Ribble Valley Borough Council
Housing & Development Control

Your ref: 3/2023/1011
Our ref: D3.2023.1011
Date: 4th March 2024

Application no: **3/2023/1011**

Proposal: **Change of use of upper floors (use class E) to C3 (dwellings) and construction of additional storey to rear at second floor level to form five self-contained flats.**

Title: Existing and Proposed Site Plans	Drawn: HA
Client: Wajid Mahmood	Checked:
Date: 30-11-2023	Paper: A3
Drawing No: HAD3858-09	Scale: 1:200
Revision:

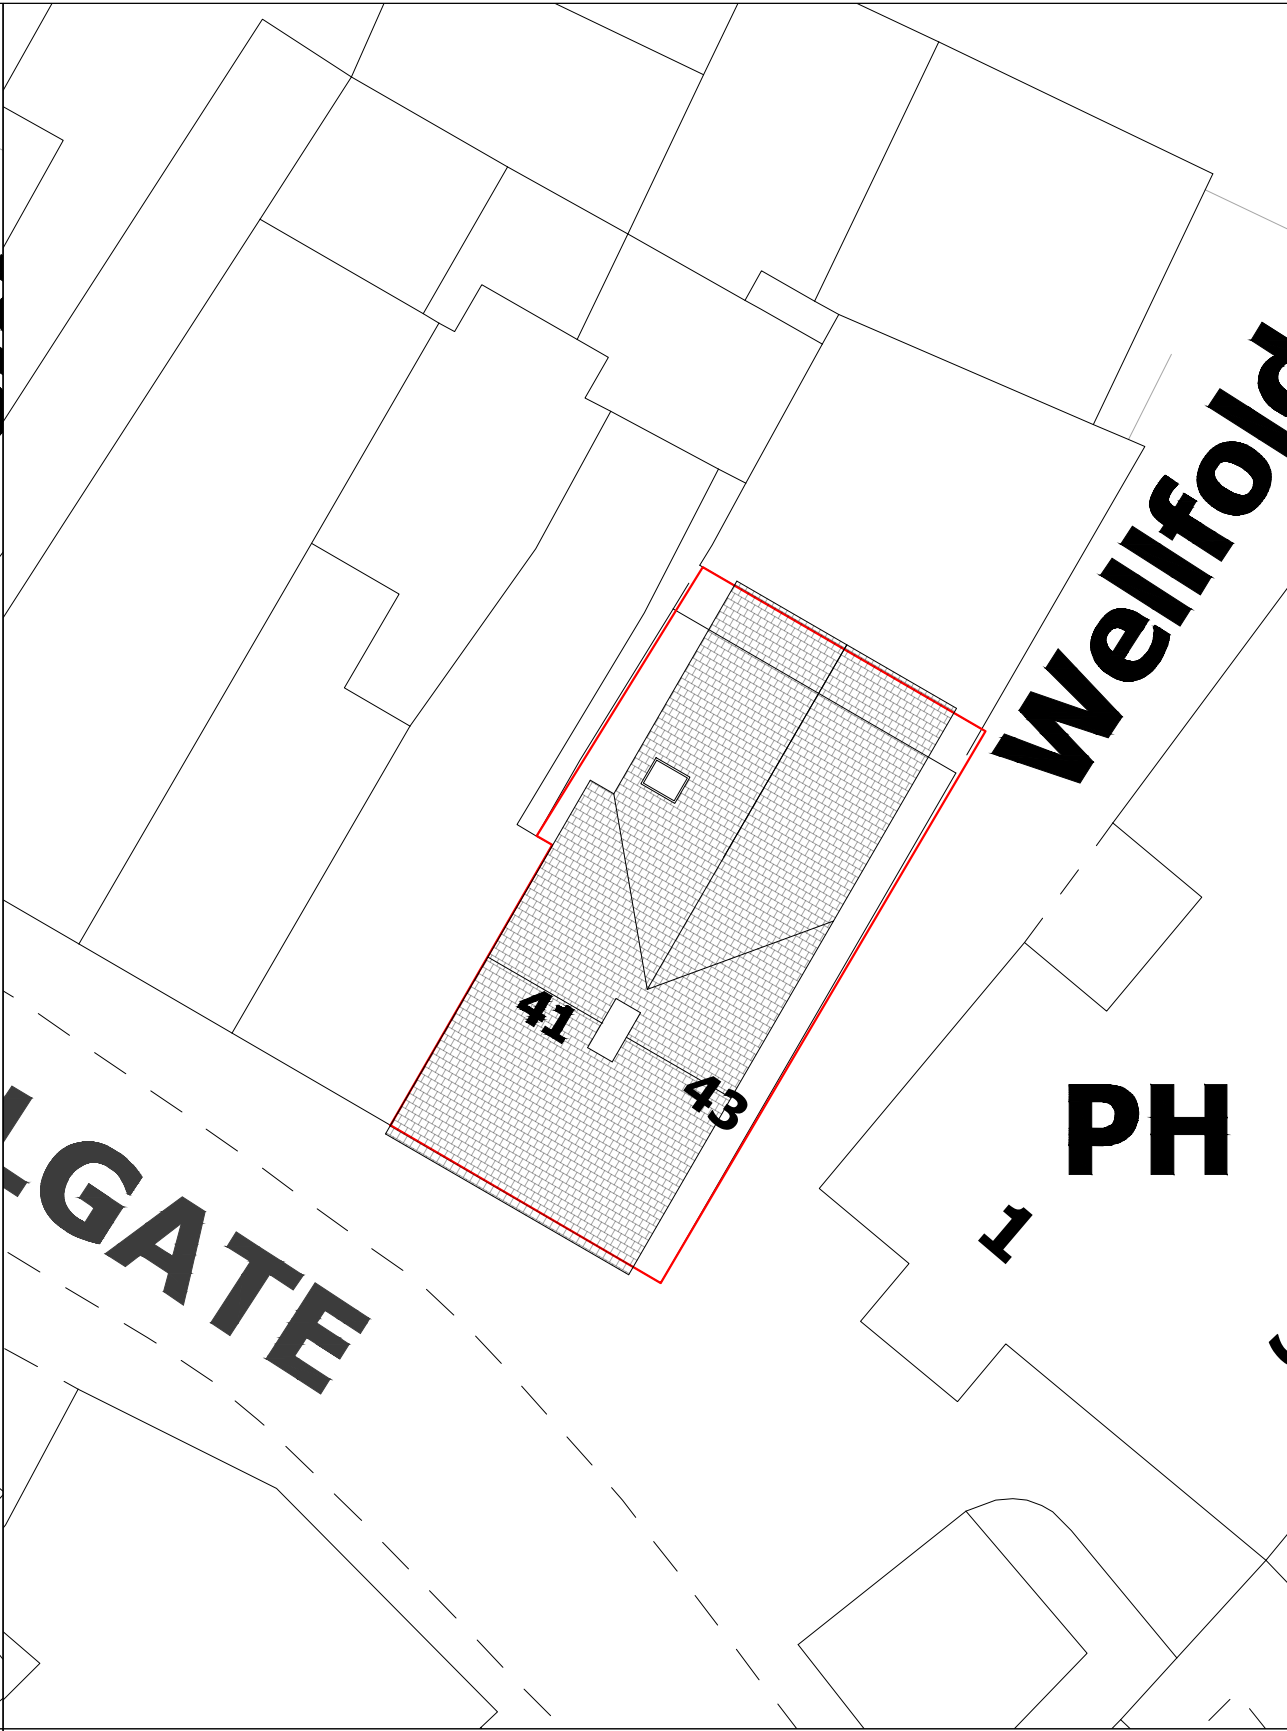
The site will not provide any off-street car parking facilities for the existing ground floor Class E use as well as the proposed one bedroom flats. The proposal, as a result, does not comply with the LHAs parking guidance as defined within the Joint Lancashire Structure Plan, which requires the site to provide 5 car parking spaces for the 5x one bed flats. While the existing Class E use is expected to provide 1 car parking space per 8 square metres.

Despite this, the LHA will accept the shortfall in parking. This is because the site is located in a sustainable location in the centre of Clitheroe where public transport services are provided with the bus station and railway station being located a short walking distance away. The site is also within walking distance of the town centre where key local amenities such as shops and schools are located.

The lack of parking facilities should deter prospective tenants and favour those without access to a private vehicle, but should they have access to one there are public car parks within walking distance of the site. There are also Traffic Regulation Orders (TRO) within the vicinity of the site with some of these TROs including limited waiting bays along the east side of Wellgate. These limited waiting bays are in operation Monday-Saturday 9am-7pm. On the west side of Wellgate, there is another TRO which prevents vehicles from waiting on the adopted highway at any time. These TROs should prevent future occupants parking inappropriately on the adopted highway.

Given the existing measures in place to prevent inappropriately parking and the site being located in a sustainable location, the LHA have no objection to the proposal. The LHA will request that a shared cycle storage facility for the occupants of the site is provided. Each flat should have access to a minimum of one cycle space.

2. No building or use hereby permitted shall be occupied or the use commenced until a cycle storage plan for the residential units has been submitted to the Local Planning Authority, in consultation with the Local Highway Authority. These cycle facilities shall thereafter be kept free of obstruction and available for the parking of bicycles only at all times.
